7'x23'
1 story addition
built w/out a permit

* This permit is permitting
this addition? allowing
a second story over the
7'x17' section - new construction

FIRST FLOOR, FLOOR PLAN

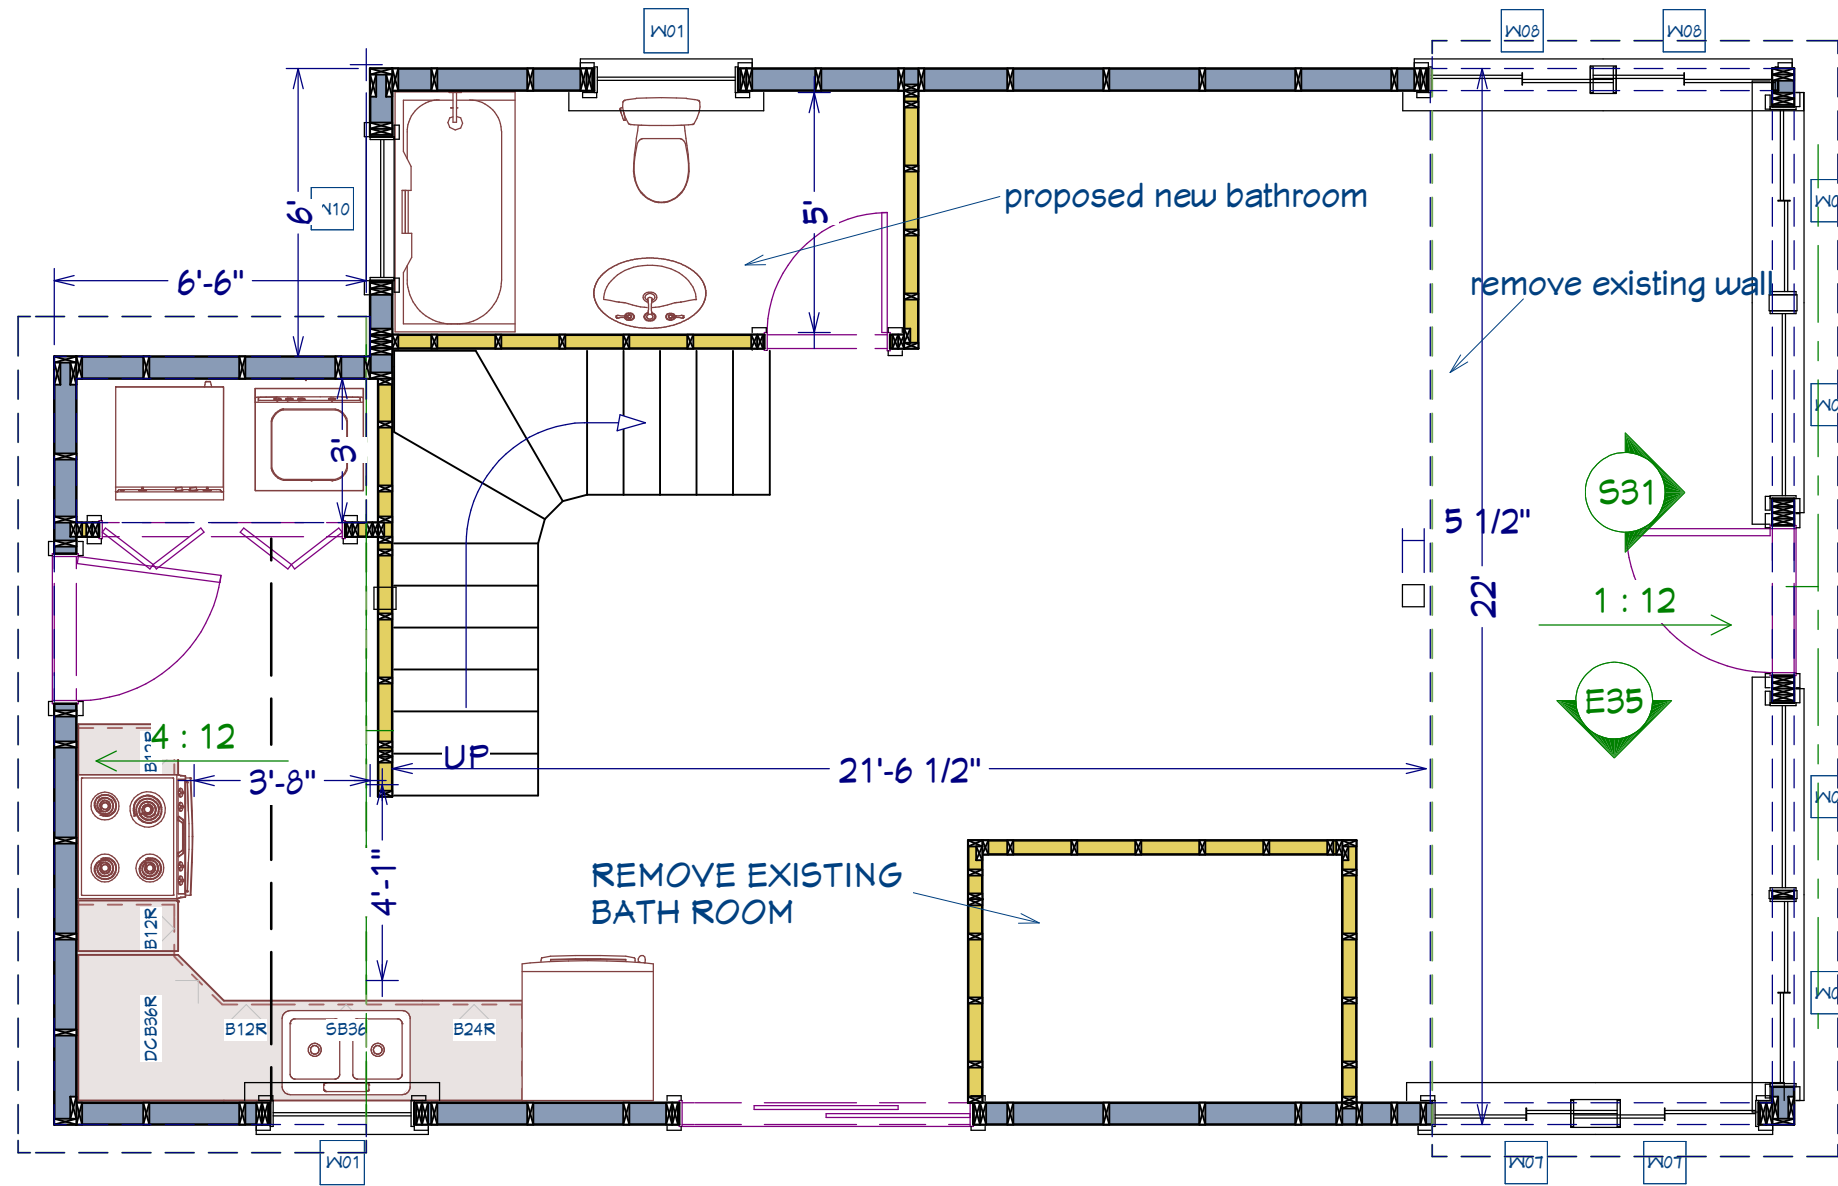
first floor
Permitted footprint is = 595 ϕ

80% = 476

22x15 =	330
9x6 =	54
8x22 =	176
7x5 =	35
	<hr/>
	595 ϕ

SECOND FLOOR, FLOOR PLAN

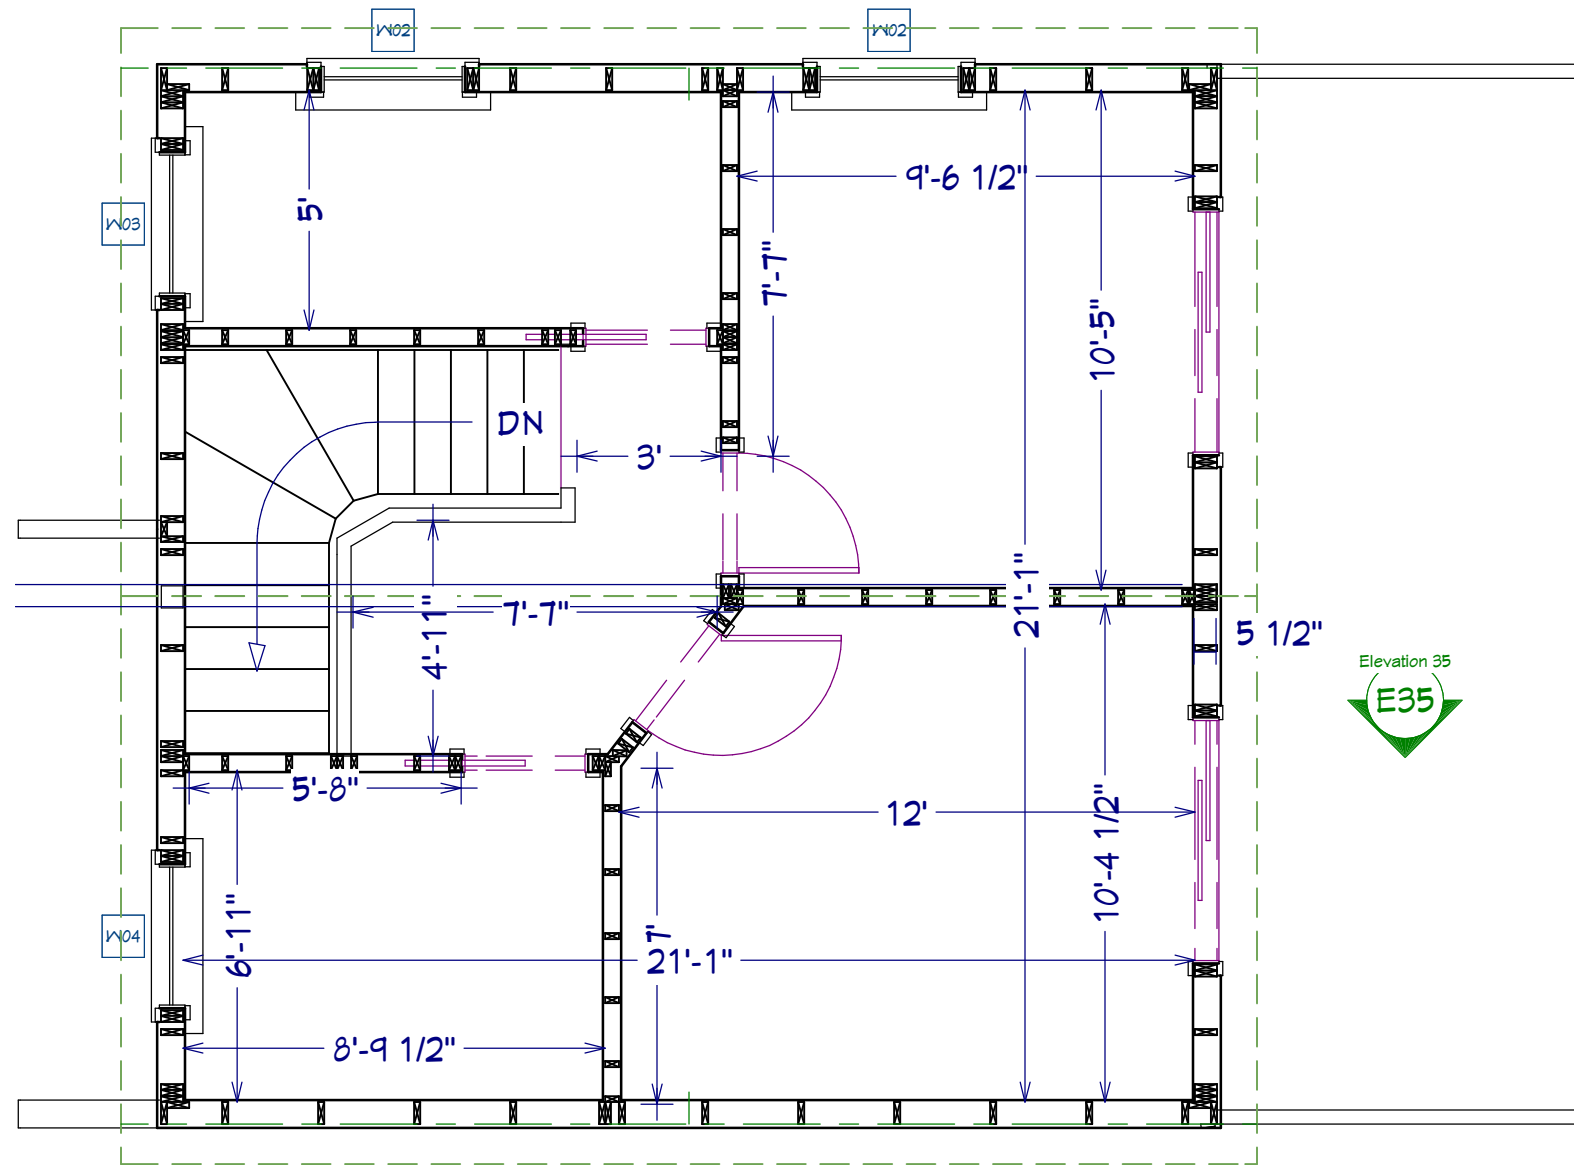
- adding existing dormer on both sides of 15'x22 section
- adding 5x7 - 35 ϕ over 1st floor existing area.
- don't know length of dormer - but could add full 2nd floor of 330 ϕ + 35 ϕ and be below 80% allowable

$$\frac{365 \phi}{476 \phi} = 76.7\% \text{ increase}$$
